Department of Industry

Genesis Waste Management Facility Modification 7 (06_0139) Environmental Assessment

DoI Water

BASIN A
 TOP LEVEL RL = 70.55
 BASE RL = 59.00
 TWL = 70.30
 SIDE SLOPES = 1:2
 VOLUME = 38.20ML

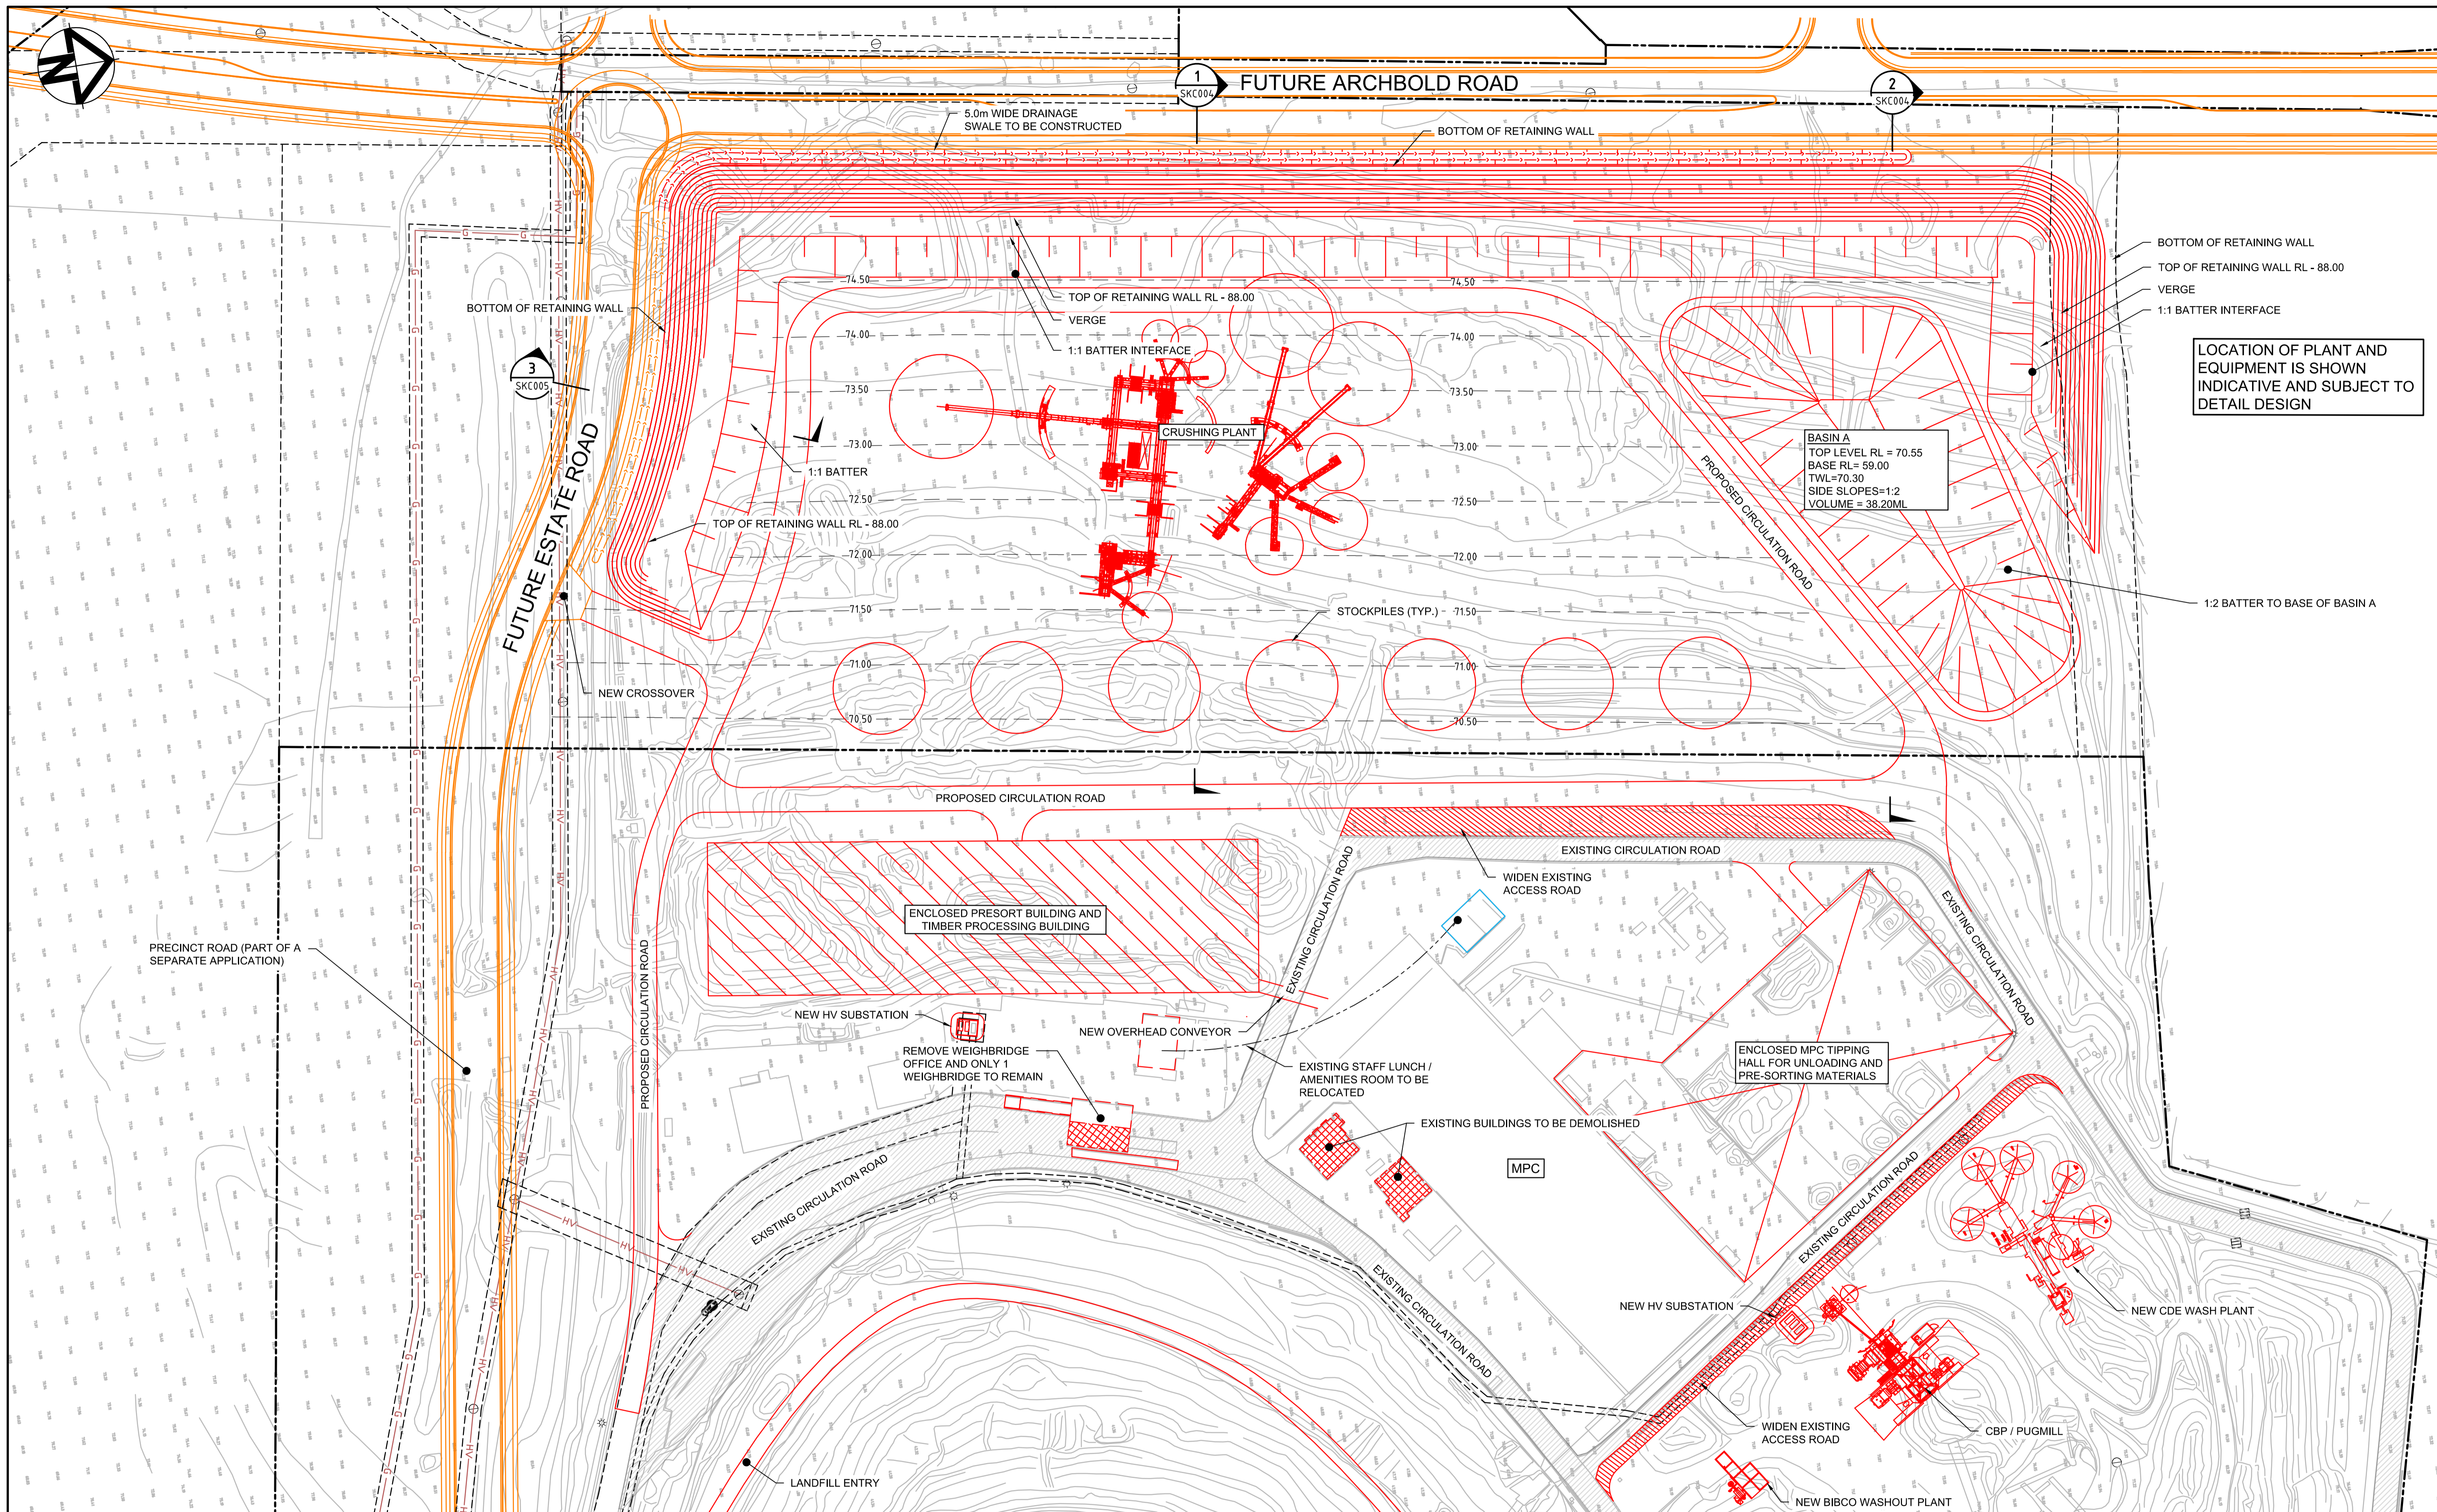
The Department notes that the detention basin is an excluded work under Schedule 1 of the Water Management (General) Regulation designed solely for the capture of dirty water and is therefore exempt from requiring a Water Access Licence. However, should the detention basin capture clean water, a licence will be required to account for the volume of clean water intercepted by the detention basin.
